RE: Case Reference: 320916, 320095 and 320094

Applicant: Coolpowra Flexgen Limited

Development: BESS, GAS Plant and GIS Substation

TYPICAL SECTION THROUGH STREAM CROSSING No. 1
SCALE 1:25

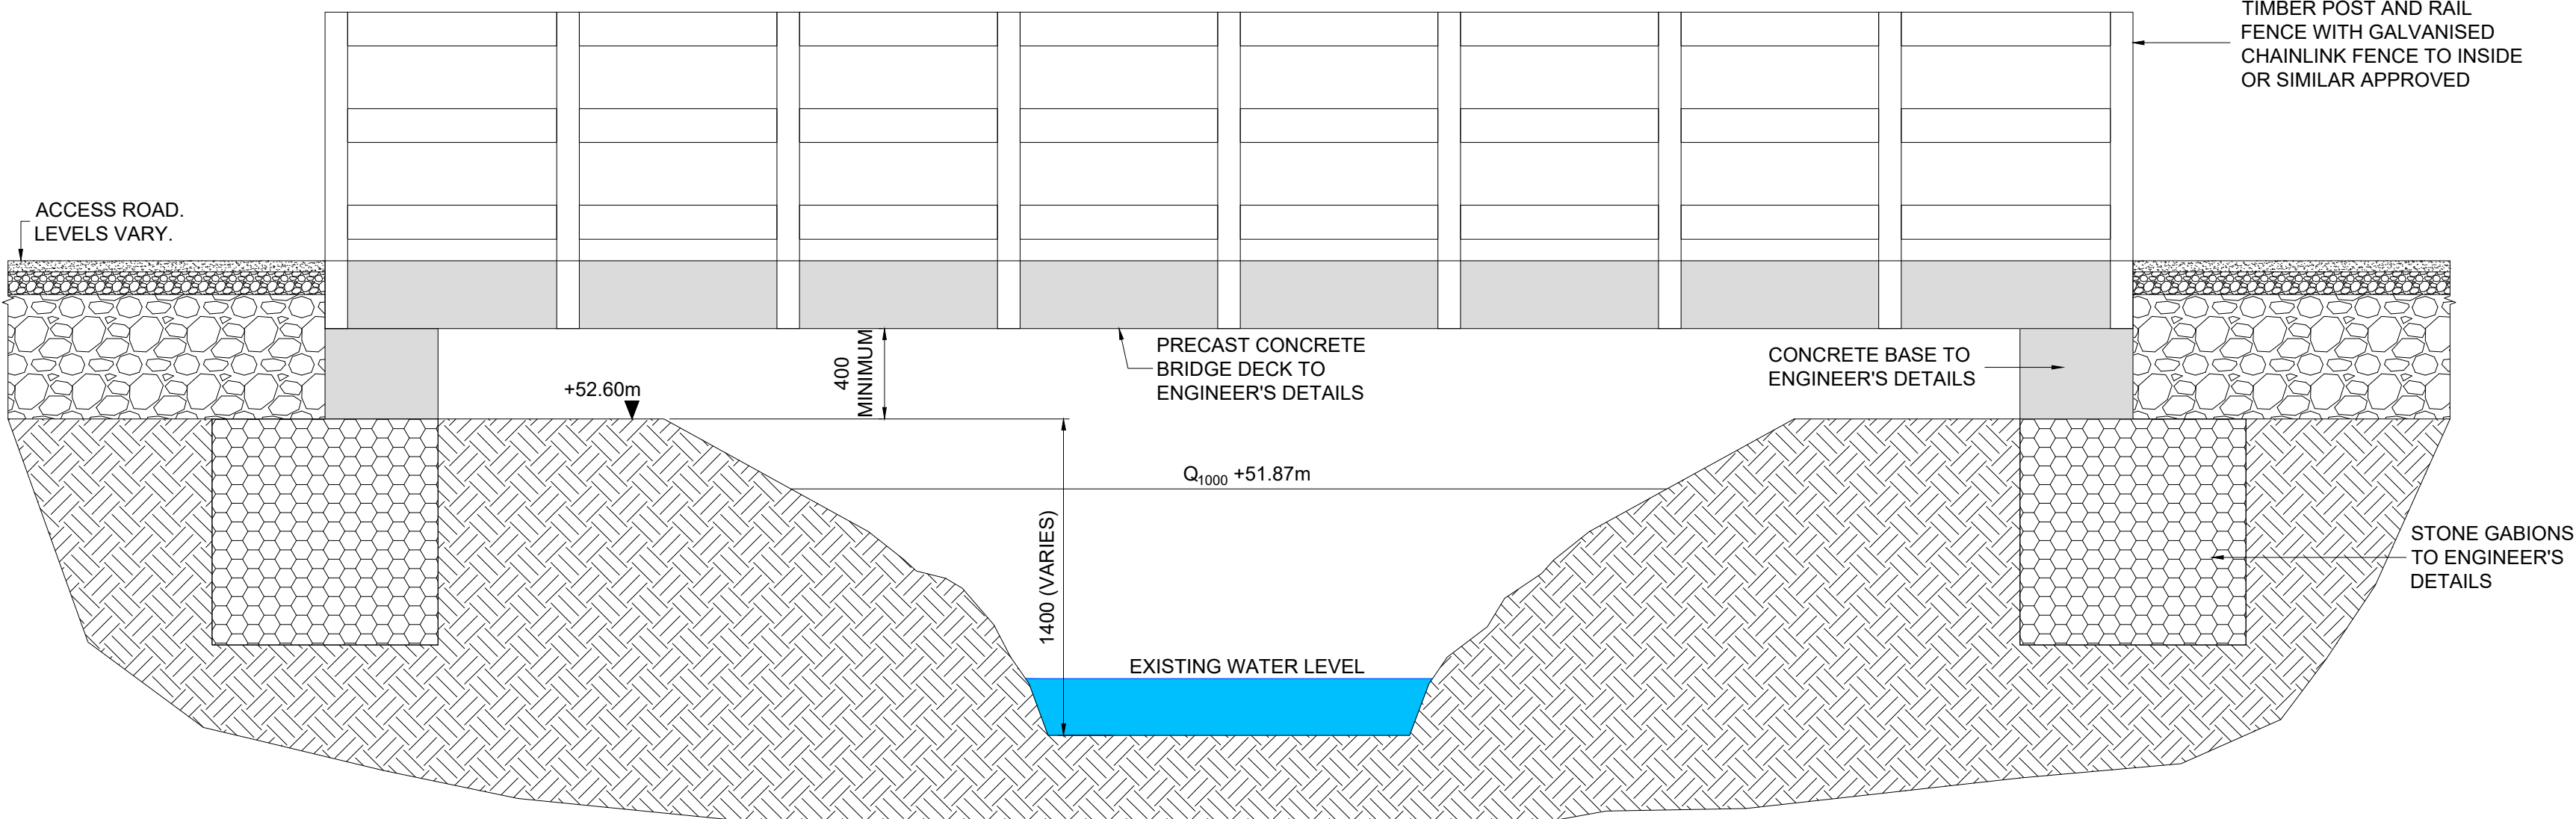
- **Redirection of Treananearla stream:** redirecting a small section does not avoid that fact that the majority of this stream will still travelling through the centre of this large scale site, in particular closely bordering 2 sides of the BESS. Should there be a fire at the battery facility (which is not uncommon in Ireland eg Claregalway) the stream will be directly hit.
